APPLICATION BY NATIONAL GRID ELECTRICITY TRANSMISSION

**FOR AN ORDER GRANTING DEVELOPMENT CONSENT
FOR THE SEA LINK PROJECT**

(REF: EN020026)

**DEADLINE 2: PORT OF LONDON
AUTHORITY'S COMMENTS ON SUBMISSIONS
RECEIVED AT DEADLINE 1 AND DEADLINE 1A**

Plate 2.1 Stakeholder areas of interest with regard to under-keel clearance

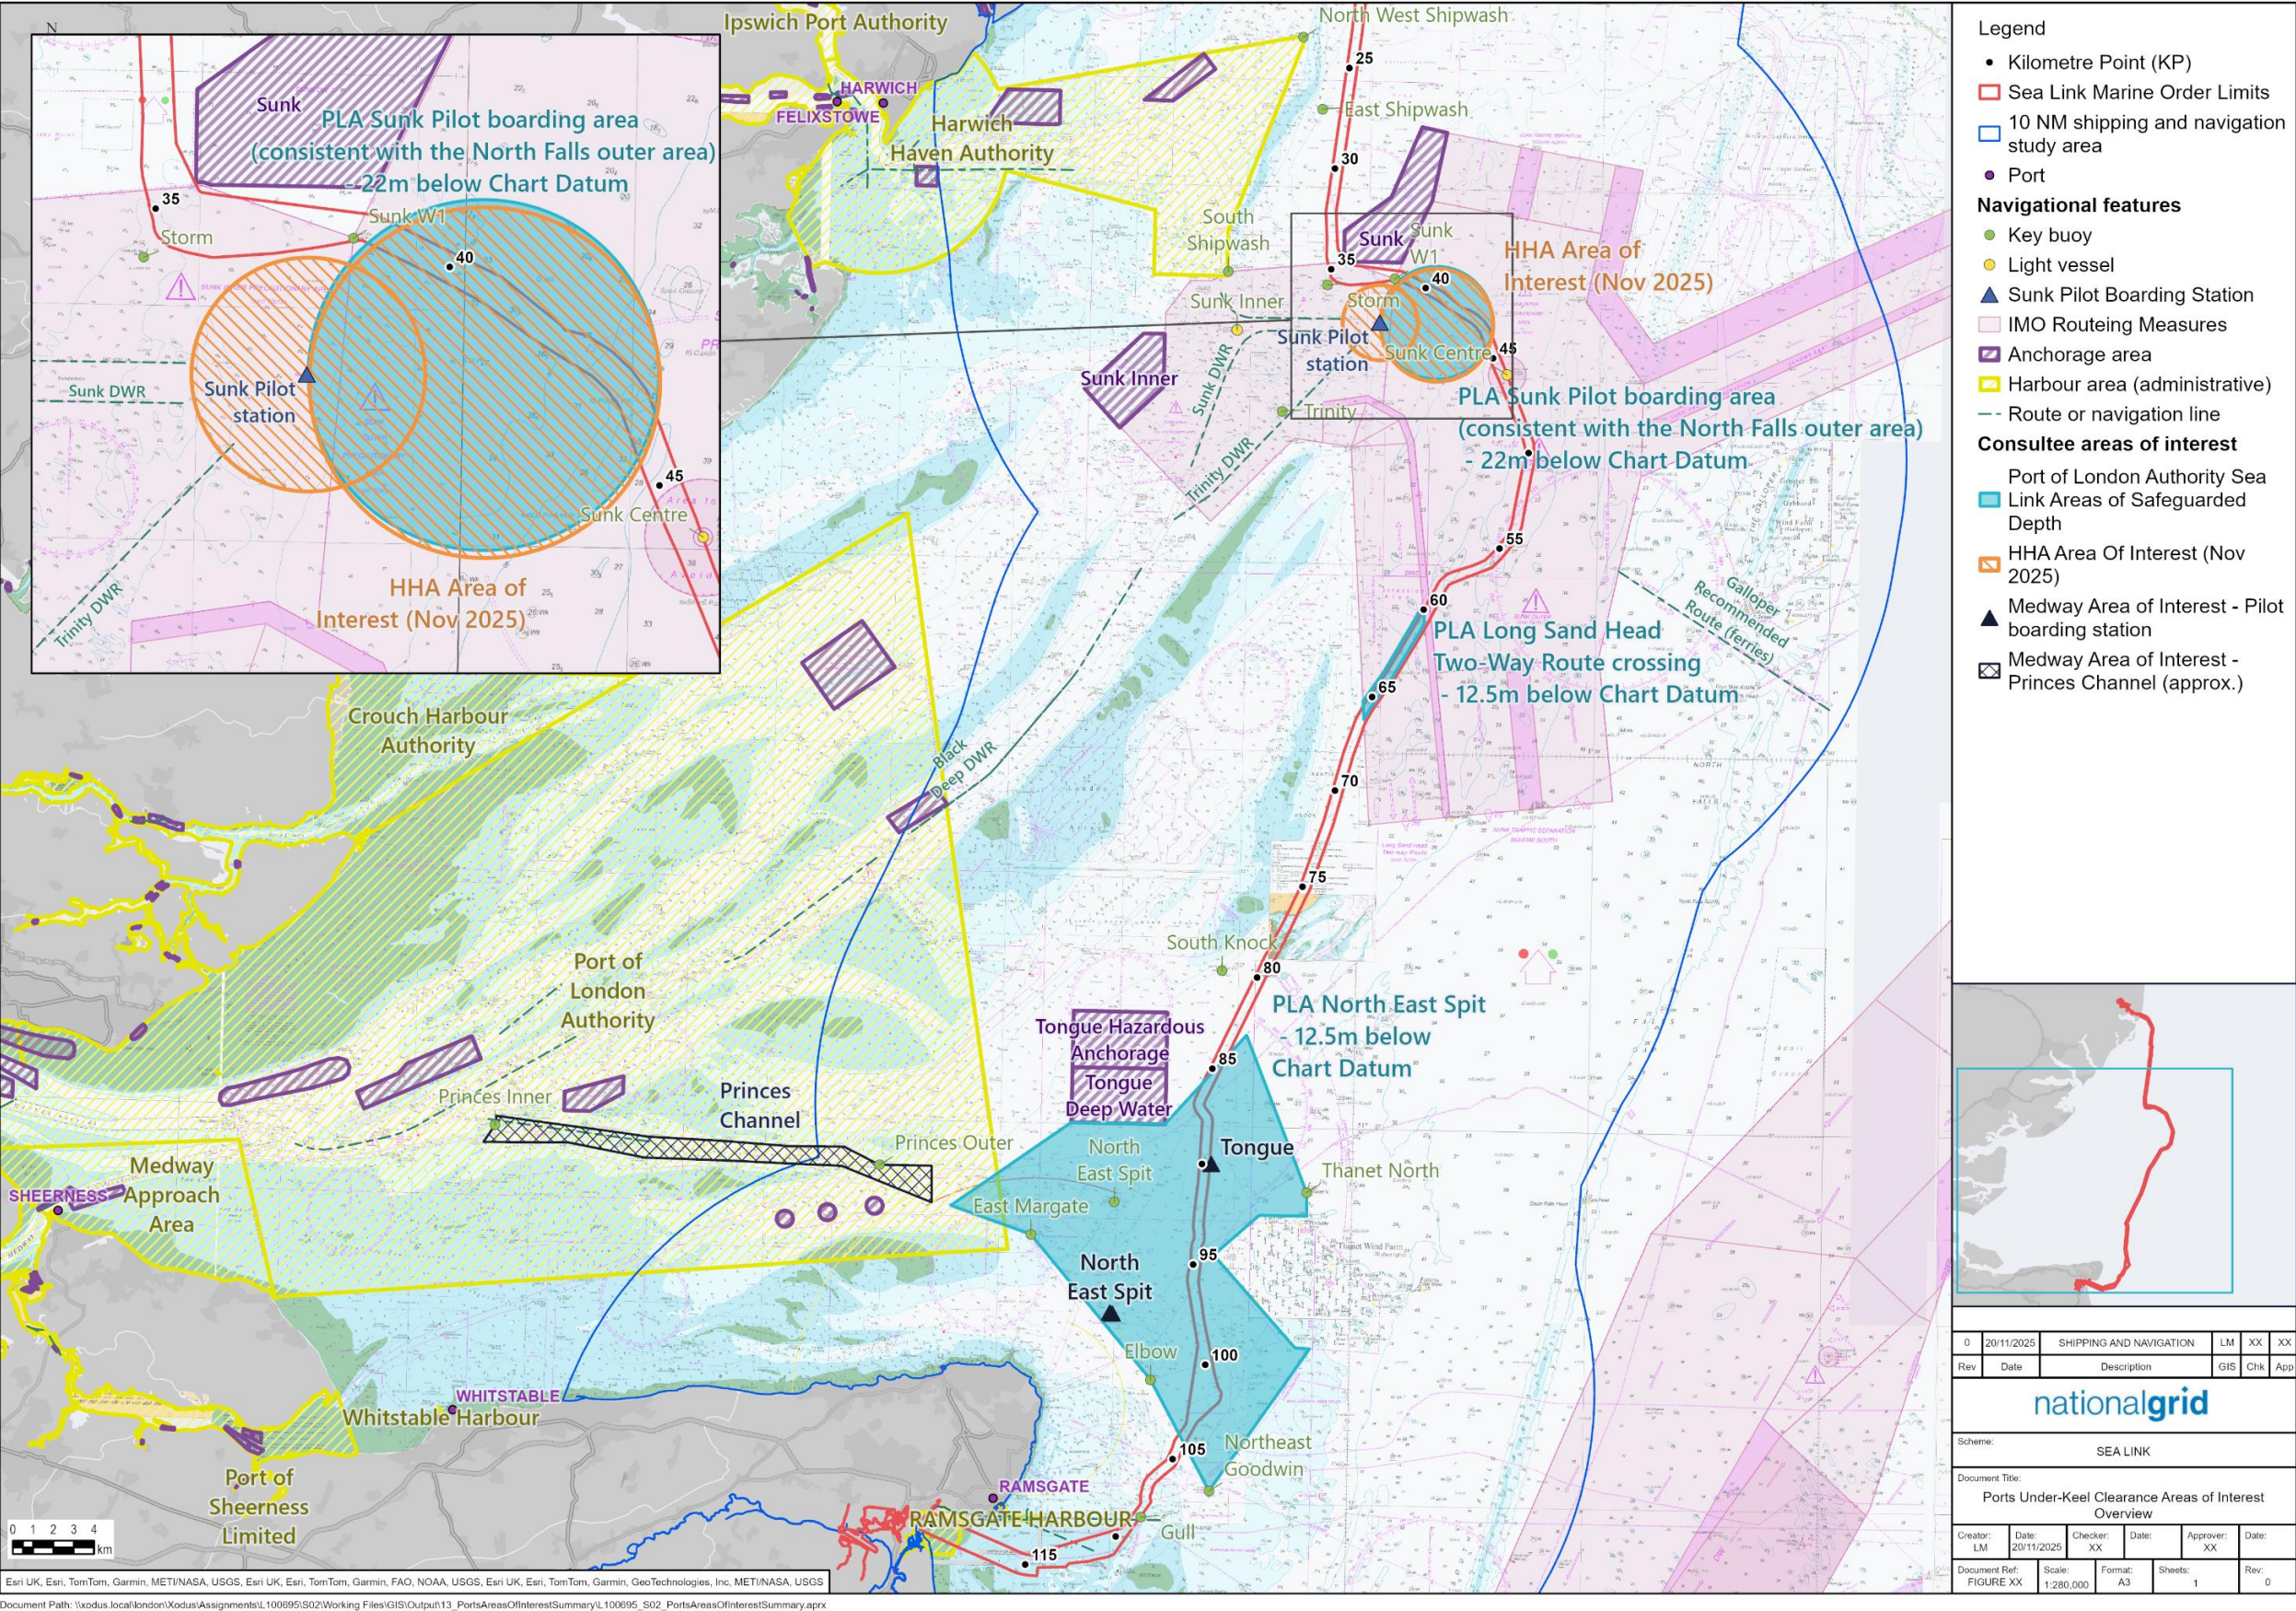
- 2.2 The Applicant's summary regarding under keel clearance sets out that there are three areas which make up the Areas of Interest, and this is shown on plate 2.1. It sets out the minimum water depths that need to be preserved and recognises the need for a 0.5m over-dredge tolerance.

- 2.3 At paragraph 2.2.2 it is stated that *"The Sunk region is of particular focus due to the high level of traffic here which route through the Sunk Traffic Separation Scheme and utilise the Sunk Pilot Boarding Station which HHA and PLA manage."* The Sunk Boarding Area is managed by Sunk Vessel Traffic Services ("**VTS**") in terms of traffic management. HHA manage the pilot boarding and landing service. None of it is managed by the PLA.
